PINS Ref: EN010090
DHA Ref: DHA/12321 Doc 6.1

EN010090 – THE KEMSLEY MILL K4 COMBINED HEAT AND POWER GENERATING STATION DEVELOPMENT CONSENT ORDER

DOCUMENT 6.1 – APPLICANT’S RESPONSE TO SECTION 51 ADVICE

Figure 9.1 - Document 4.4 - Works Plans - Key Plan

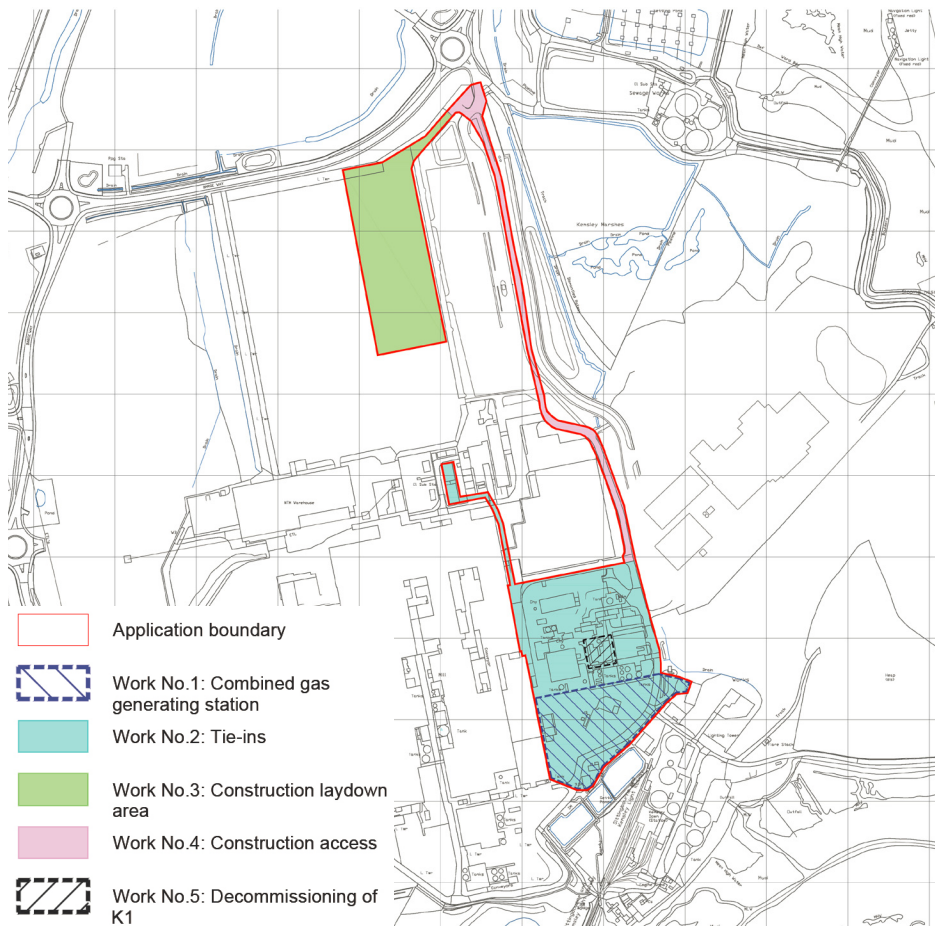
Doc Ref	Title	Change in response to S51
4.4	10392-0026-007 Works Plans – Key Plan	The area shown as 'Works No. 1: Combined Gas Generating Station' has been extended slightly to ensure it fully encompasses the extent of Work No.1 g) CHP pipe bridge.

Document number  
4.9

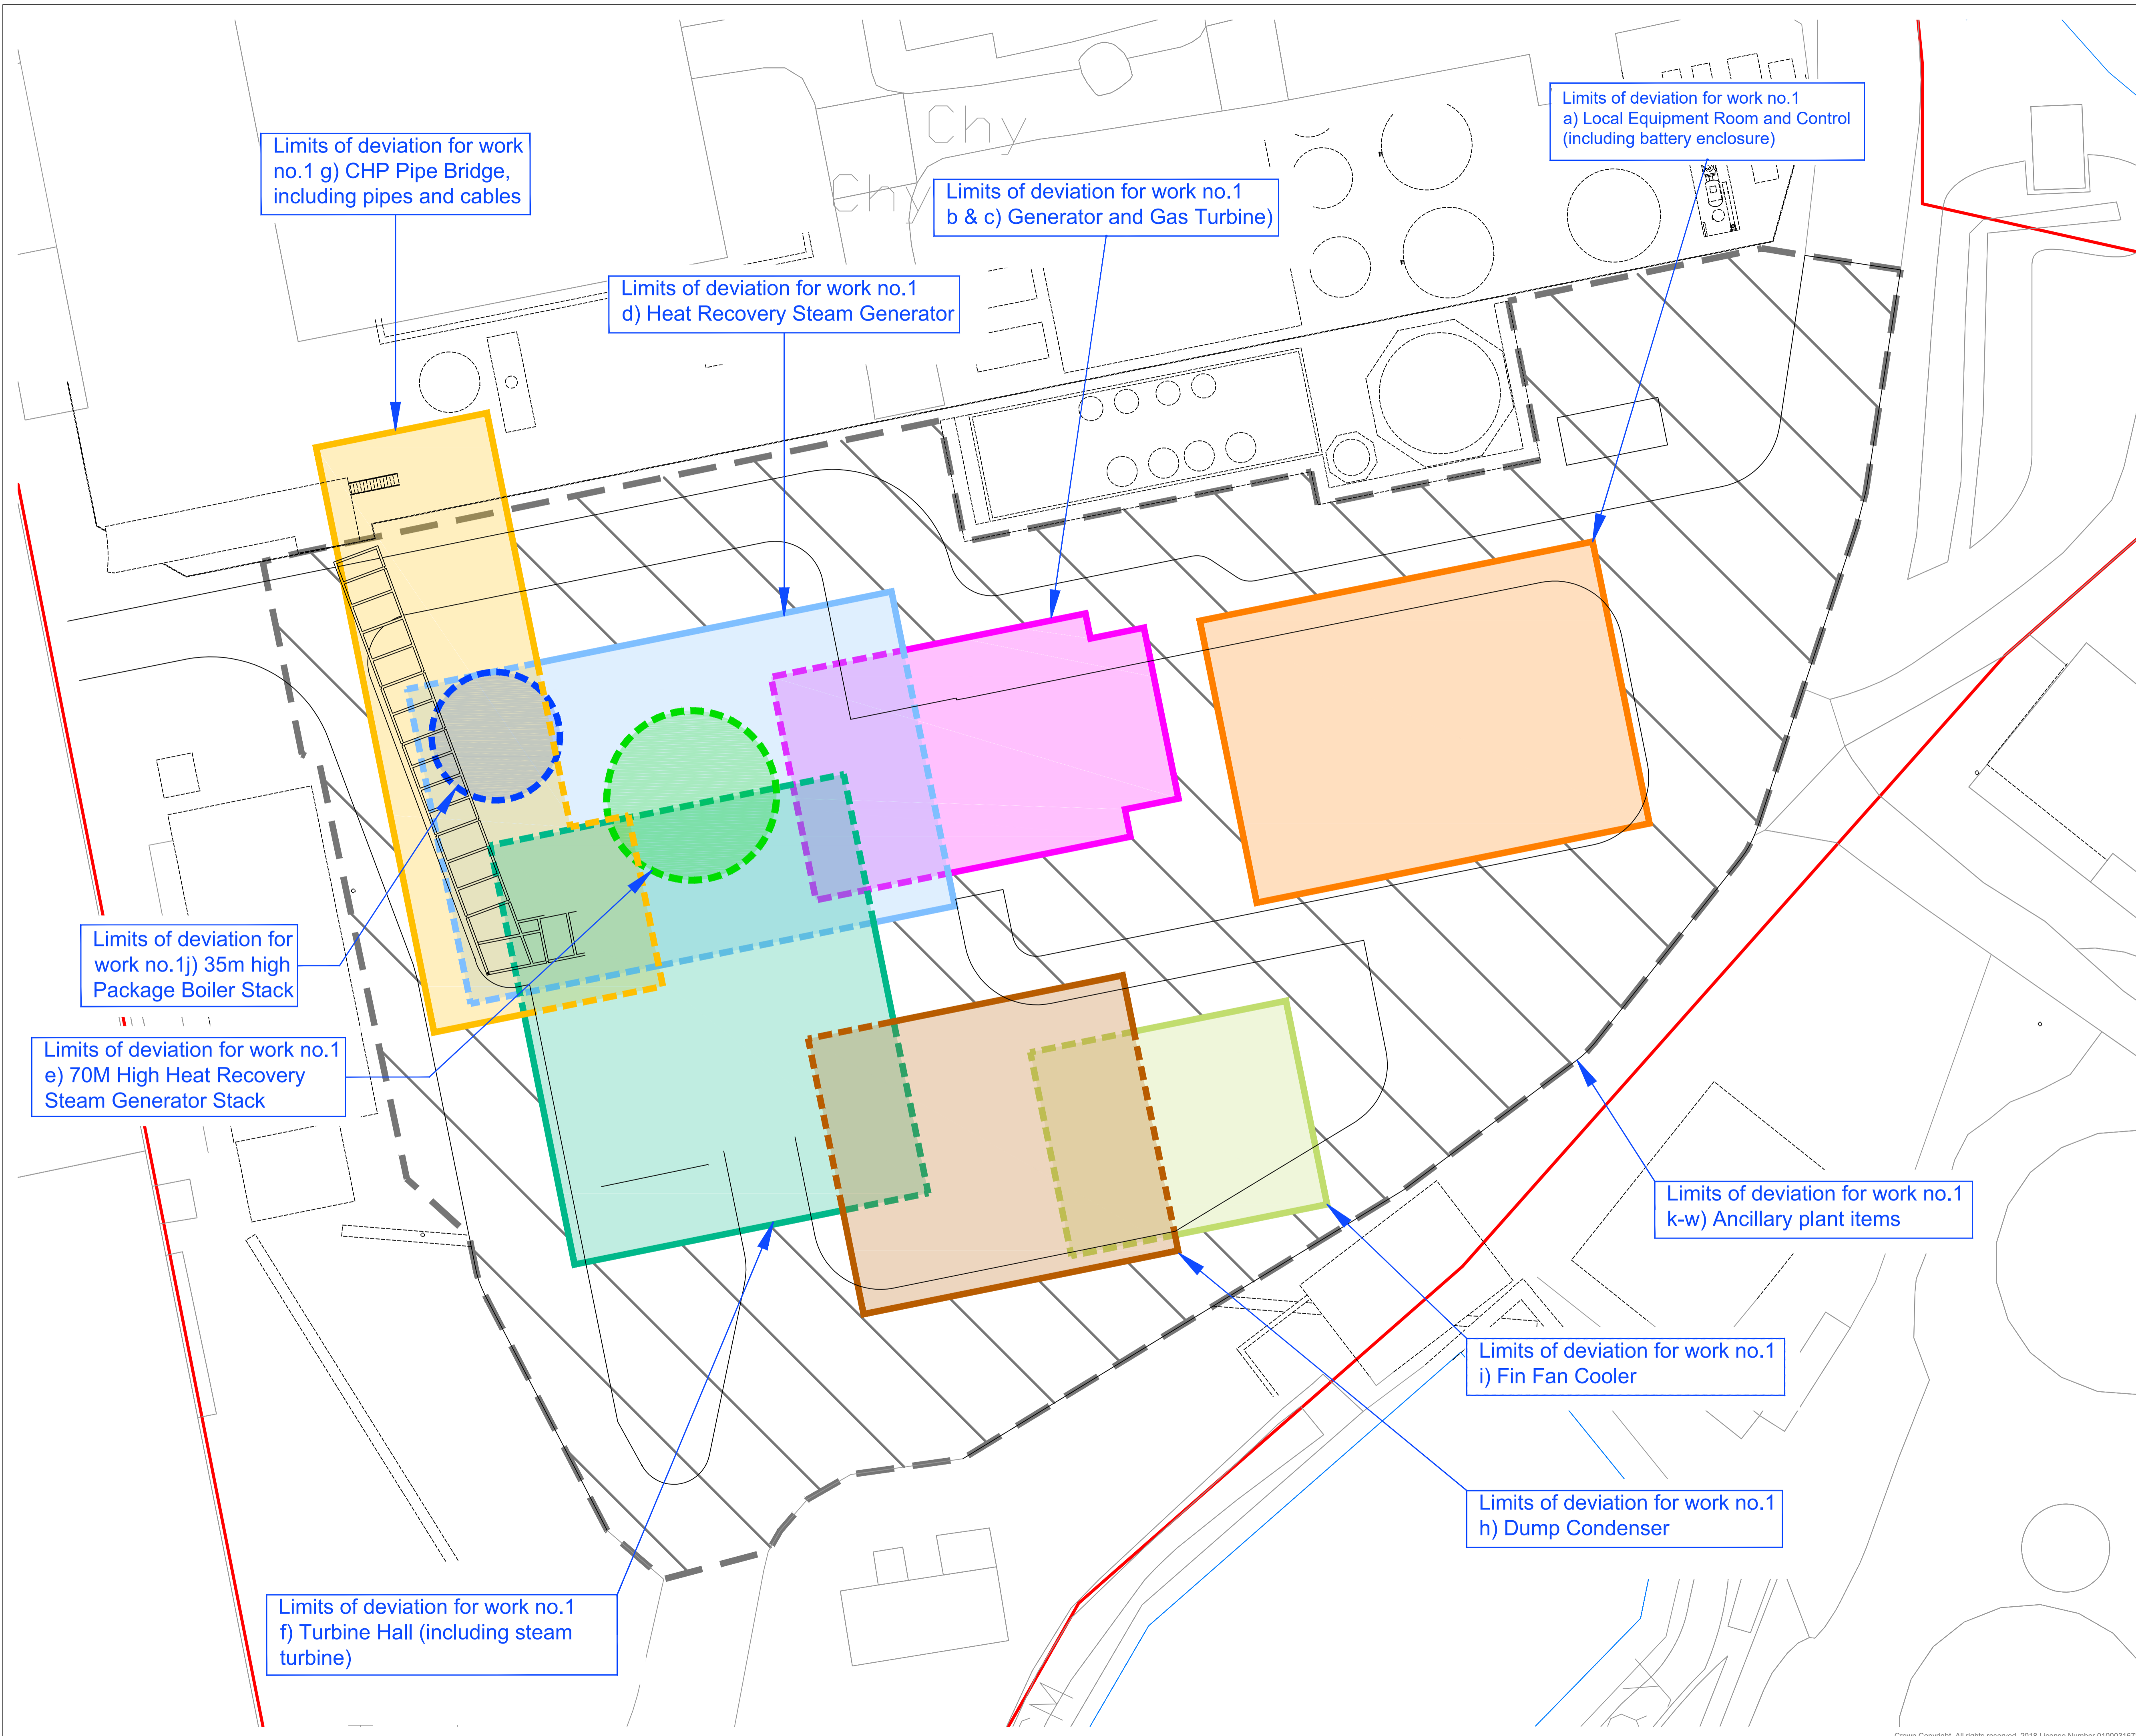
4.9	10392-0039-008 Work No.1 –Works Plan with limits of deviation for Vertical Tube Boiler	The illustrative pipebridge shown on the original version has been removed. The Limits of Deviation shown for Work No.1 g) CHP Pipe Bridge correctly reflect the Illustrative Layout with Vertical Tube Boiler shown in Document 4.10 (which as a result does not need to be amended).
